OXFORDSHIRE COUNTY COUNCIL'S RESPONSE TO CONSULTATION ON THE FOLLOWING DEVELOPMENT PROPOSAL

Application no: 21/03558/OUT

Proposal: OUTLINE - Residential development for up to 250 dwellings including affordable housing and ancillary uses including retained Local Wildlife Site, public open space, play areas, localised land remodelling, compensatory flood storage, structural planting and access. Details of Amendment: Technical Note - Highways Section 106 and 278 Contribution Review

Location: Land On The North East Side Of Gavray Drive Bicester

Figure 3.1 Pedestrian and Cycle Survey Locations

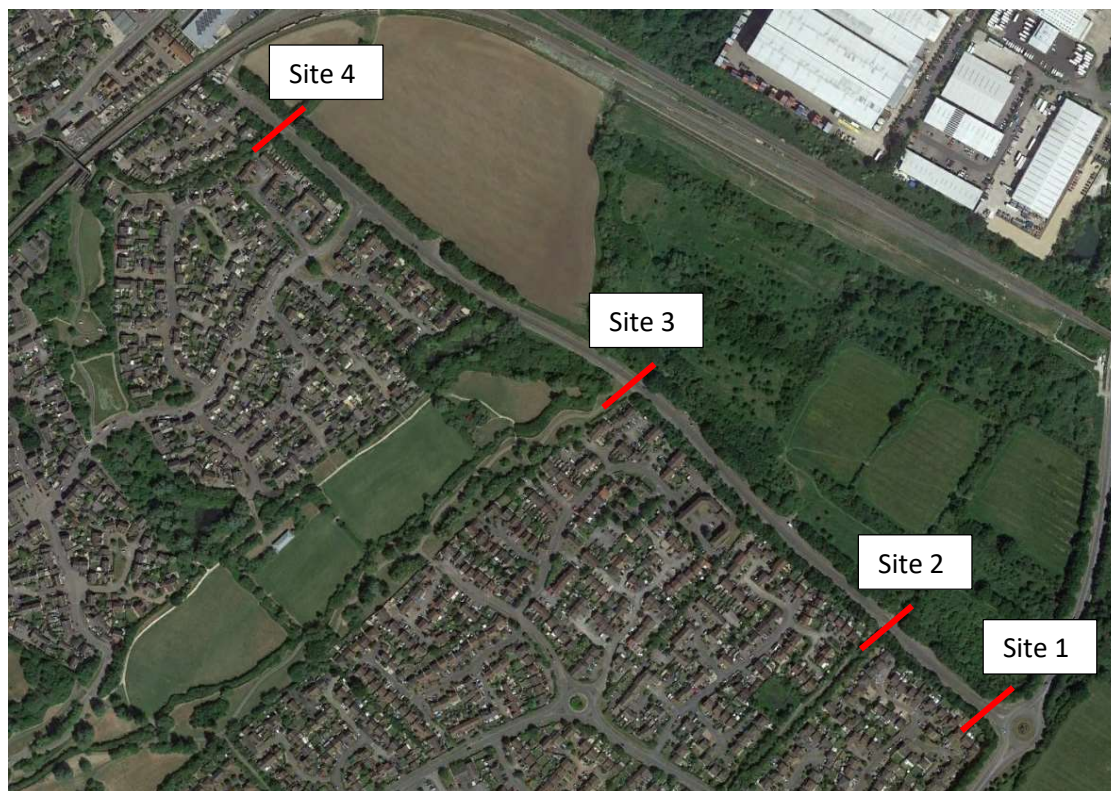
Gavray Drive forms the south-west boundary of the site over a distance of approximately 1.0km and will form a pedestrian and cycle link to the town centre and wider active travel network. The existing path on the south-west side is approximately 3.0m wide and has a white line to distinguish between the pedestrian and cycle lanes. 6.5.2 of LTN 1/20 notes *“This form of separation is not well observed...”* while 6.5.3 says *“White line segregation is not recommended...”*

The highway boundary is along the back edge of the existing path over the majority of the 1.0km length. This has been measured in several places to be between 5.1 and 5.2m from the kerb. Therefore, there is insufficient land available to accommodate full standard LTN 1/20 facilities consisting of a 3.0m wide cycle track, physically separated from a 2.0m wide pedestrian path, while maintaining a 0.5m wide buffer from the carriageway.

Internal discussions within OCC have concluded that the most appropriate facilities would be parallel pedestrian and cycle tracks, both 2.0m wide, and a 1.0m wide grass verge buffer that would accommodate the street lighting columns. As there is not space to have any physical segregation between the pedestrian and cycle facilities, it is proposed to differentiate the two sides using surface treatments as well as appropriate signage and markings. This approach has been used at Graven Hill (see Google Streetview image below) although the use of paving slabs is not suggested. A different colour surface for the cycle track is recommended. It may also be possible to introduce a 50mm step between the two tracks (see Figure 6.10 of LTN 1/20).

The works to the existing path would, therefore, comprise a 1.0m widening into the verge and modification to part of the existing surface. Lighting columns would need to be moved within the verge as necessary.
